MP 07_0158 MOD 2 - Abercrombie Street Precinct

I am writing as a parent of a child that attends Darlington Public School to object to the proposed development by the University of Sydney, MP 07_0158 MOD 2 – Abercrombie Street Precinct, Syd Uni. The school is directly adjacent to the western border of the project.

C1 Acoustic Fence

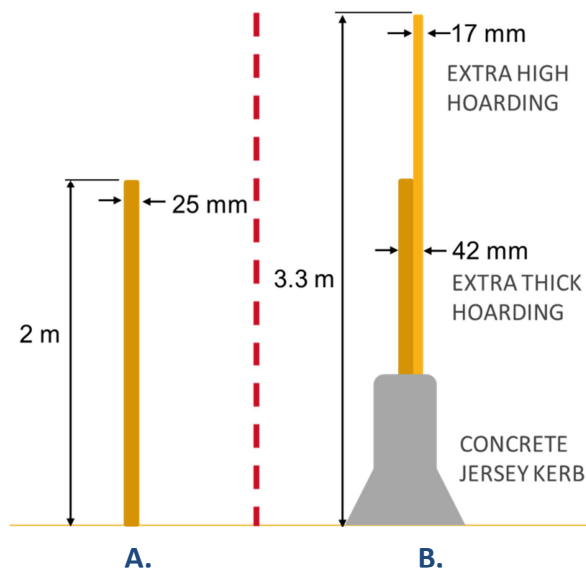
Noise, dust and contaminant levels have already been shown to be above the limits set for the development through the approval process. The standards that the development is required to meet, prior to and during construction, are not adequate for a development located beside a primary school. **Higher standards need to be set to ensure the children are protected from the impact of noise, dust and contaminants, as they will be in close proximity to the development over a long period of time.**

- 1. Higher standards need to be set to ensure the children are protected from the impact of noise, dust and contaminants, as they will be in close proximity to the development over a long period of time.**

ARCHITECT'S GROUND FLOOR PLAN: 6423 A2204 Rev C – Plan Level 1

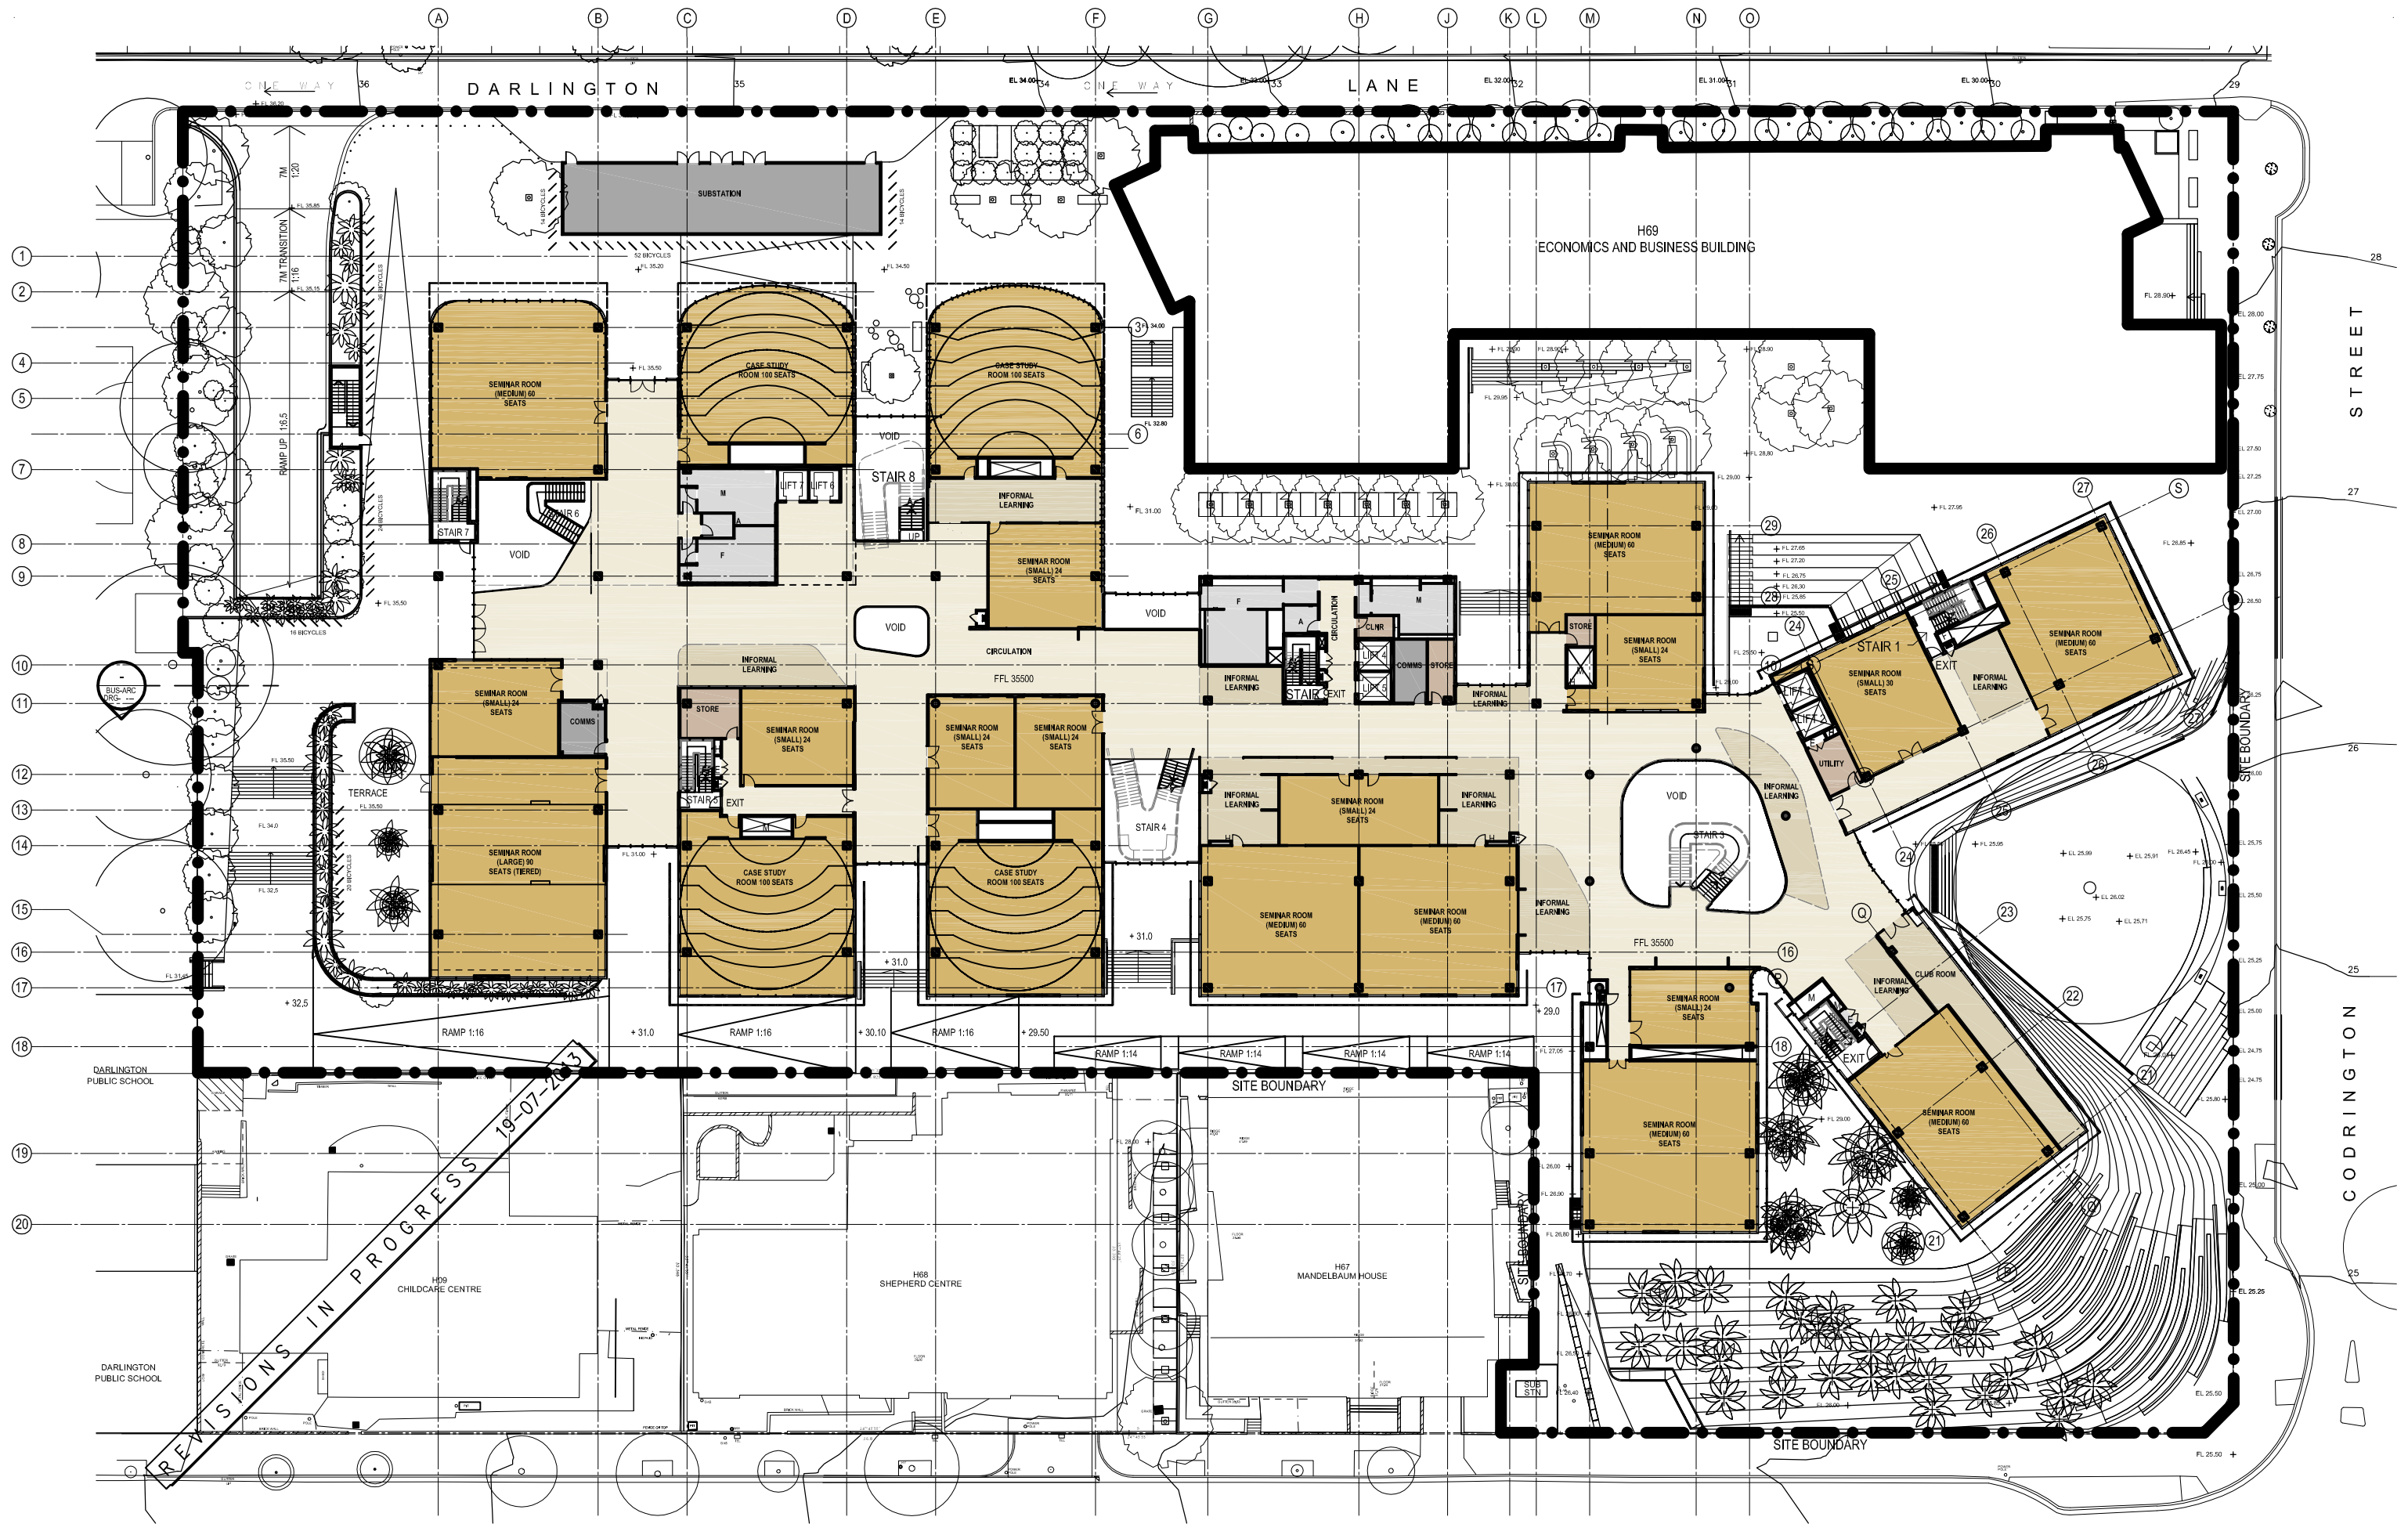
The lack of consideration for the health of the school children is demonstrated in the University locating the car park exhaust and ventilation system within 9 metres of the kindergarten classroom and playground. **The car park exhaust and ventilation system needs to be moved as far away from the children as possible – this is an unacceptable risk for small children and designed to minimise any impact on them.**

- 4. The car park exhaust and ventilation system needs to be moved as far away from the children as possible and designed to minimise any impact on them.**
